Project Name: ALBUQUERQUE HISPANO CHAMBER OF COMMERCE

RE: Albuquerque Hispano Chamber of Commerce

TO: Sheran Matson, DRB Chair
FROM: Carmen Marrone, Senior Planner
RE: **Project #1004166, Hispano Chamber of Commerce**

On June 16, 2005, the EPC approved a Site Plan for Building Permit with Conditions involving the Hispano Chamber of Commerce, located on 4th Street SW. The DRB submittal generally meets the EPC conditions with the following exceptions:

PROJECT NUMBER: 1004166

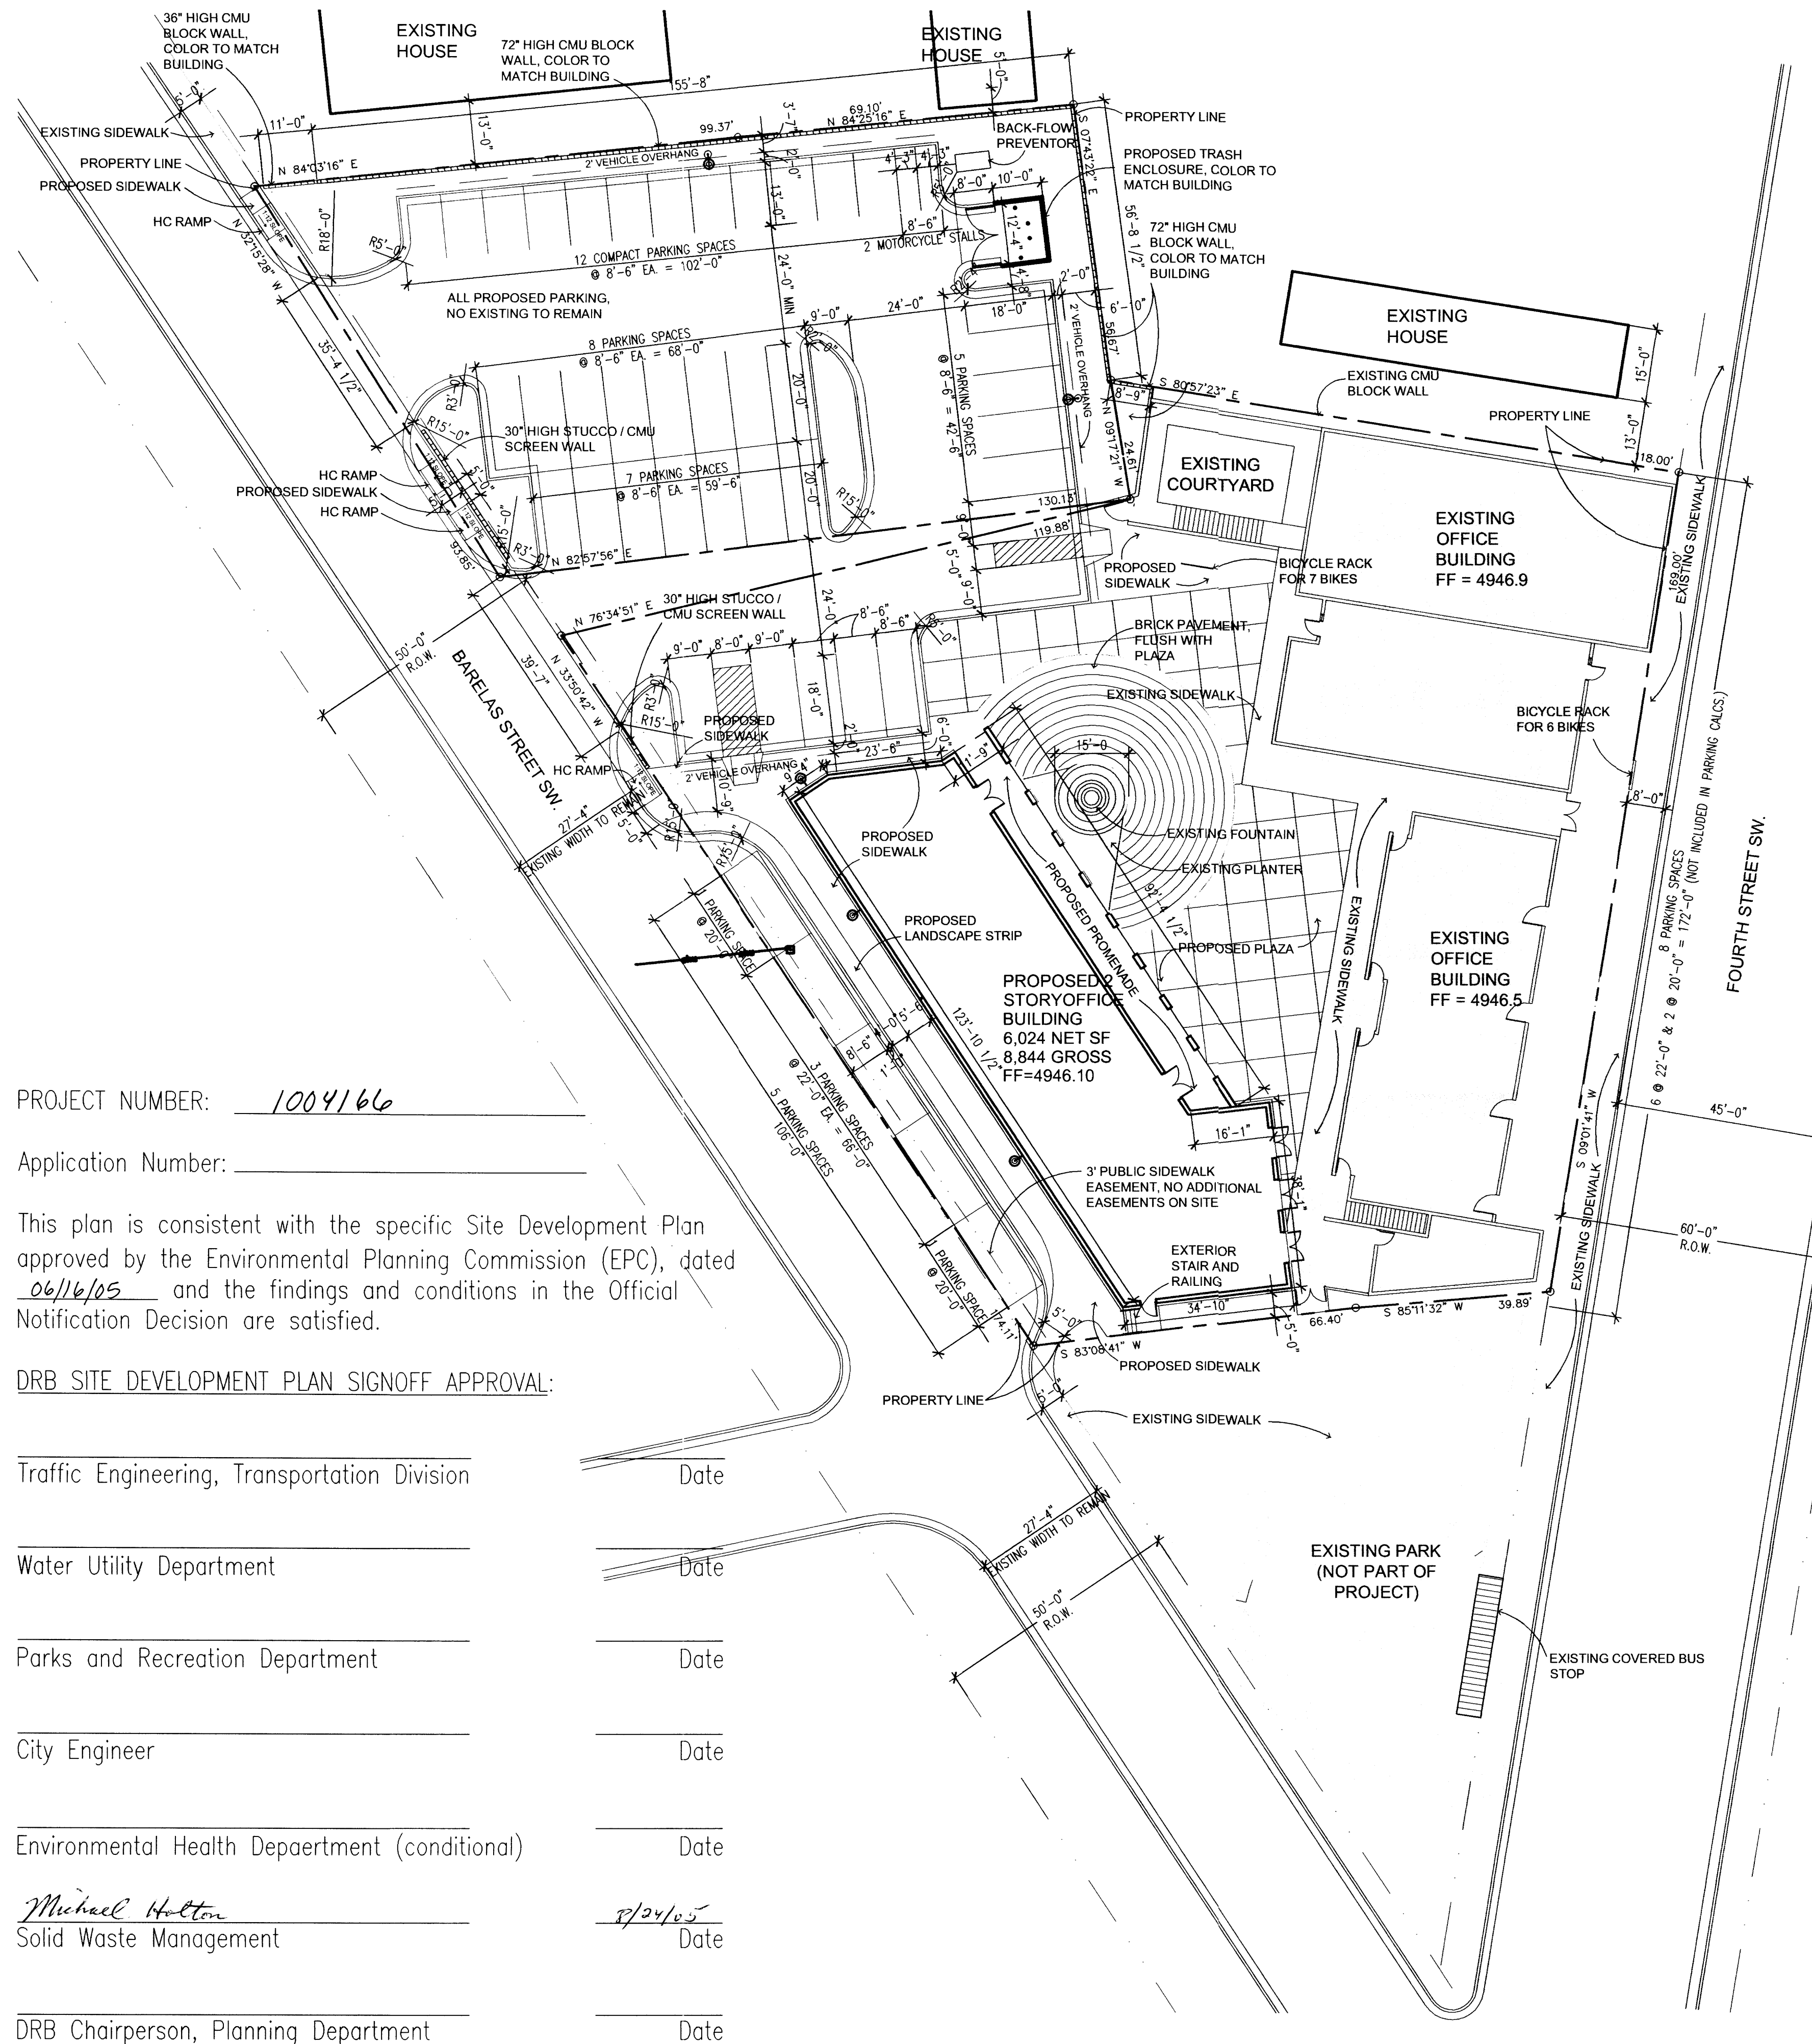
Please remove zoning note from Final Plat. A Solar Note will be needed on the plat (consistent with Section 14-14-4-7 of the Subdivision Ordinance) which is specific to this type of request, i.e. use the words "THIS PLAT" (rather than the words "REQUESTED FINAL ACTION") at the beginning of the note, and do not use the words "OR SITE DEVELOPMENT PLAN FOR SUBDIVISION" at the end of the note.

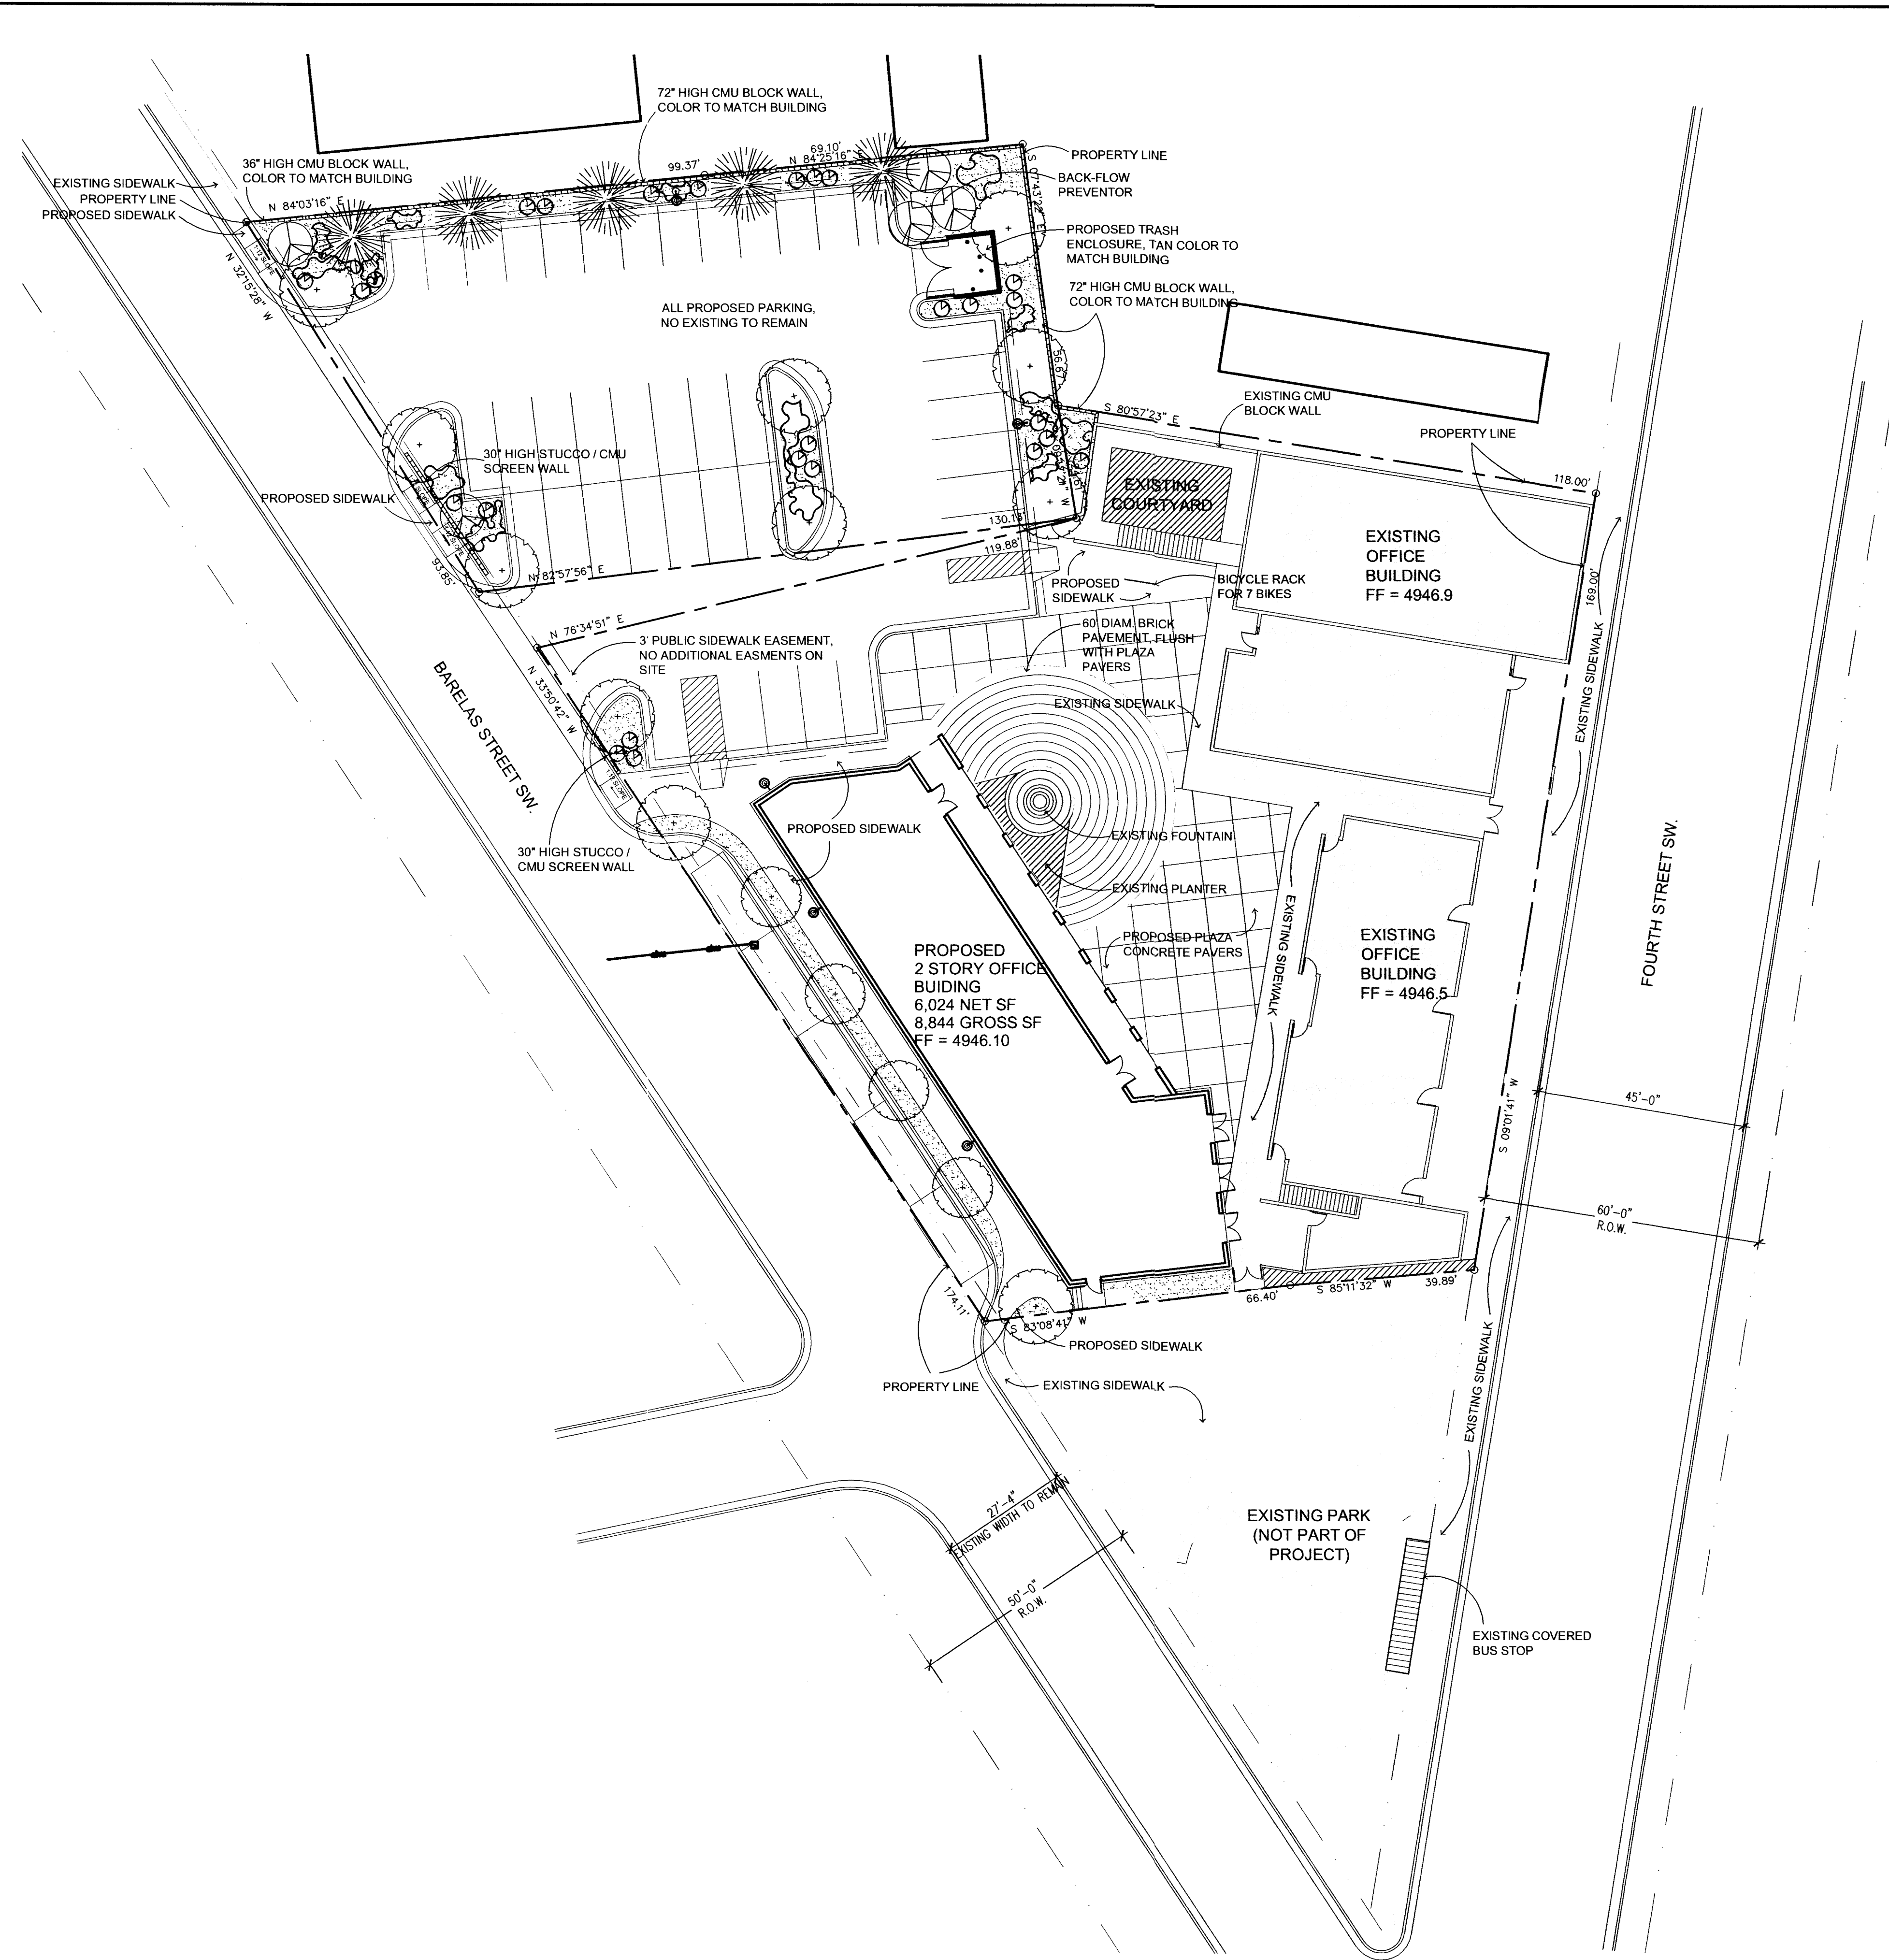
Condition 5 requires the 30" high stucco/cmu walls along Barelas Street to be removed. The current submittal still shows these walls.

Condition 6: ZHE approval of a parking variance requires that signs be posted directing patrons to the proper parking spaces. These signs must be shown on the site plan.

Condition 12 requires a minimum of 12 bicycle parking spaces. The site plan only provides 7.
